ADDENDUM NO. 5, MAY 7, 2009

RE: Ocean Avenue Elementary School City of Portland RFP No. 7109  
Portland, Maine BGS project No. 723  
A/E Comm. No. 3316.10

TO: Prospective Bidders

J1	METAL GLAD WINDOW TYPES	1/4" = 1'-0"
J4	HOLLOW METAL WINDOW TYPES	1/4" = 1'-0"

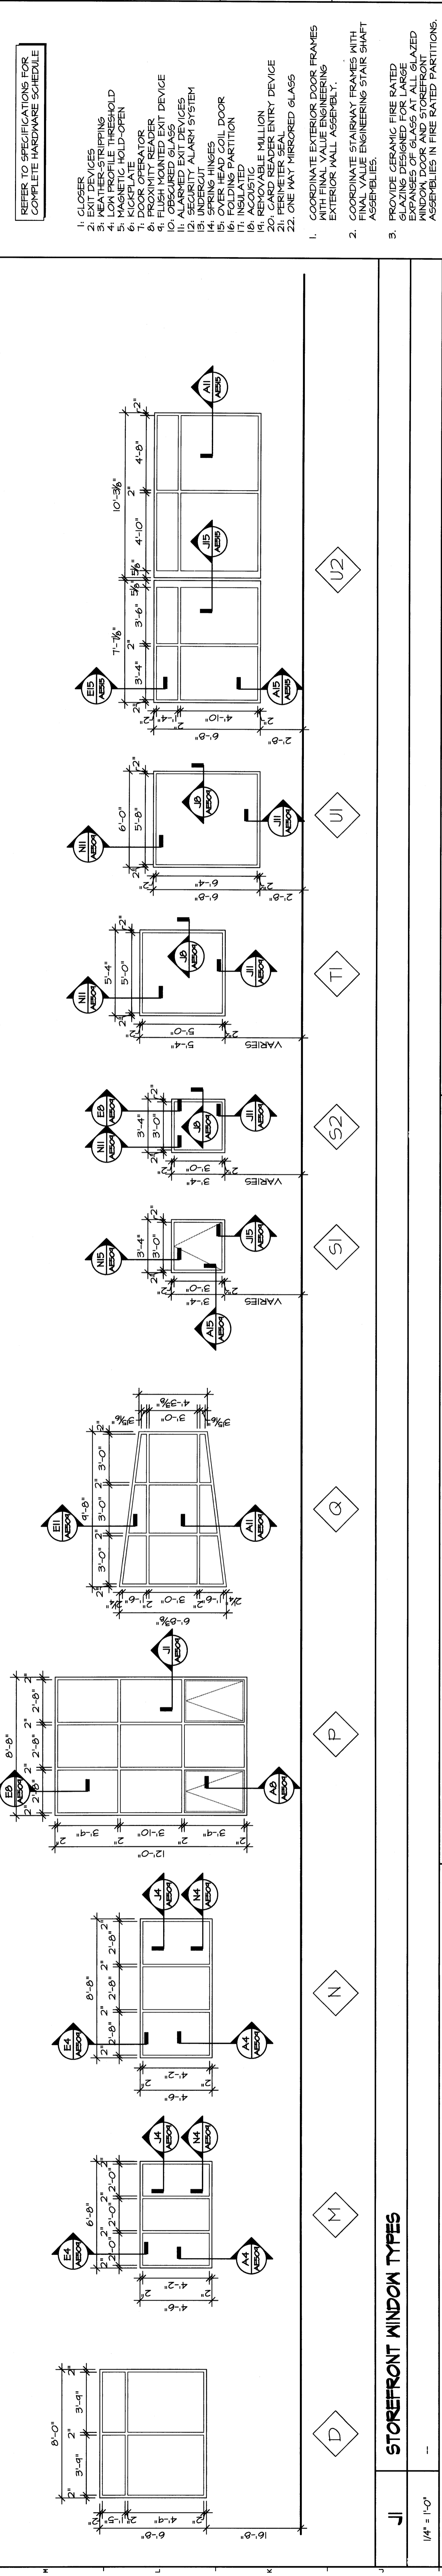
8. ALL EXTERIOR DOORS AND CONNECTING OR ADJACENT FRAMES ARE TO HAVE 1" INSULATED TEMPERED GLAZING, UNLESS NOTED OTHERWISE”
18. Sheet AE602, Door Frame and Window Types, REVISE portions as indicated on Sketch ADDAE602-1.
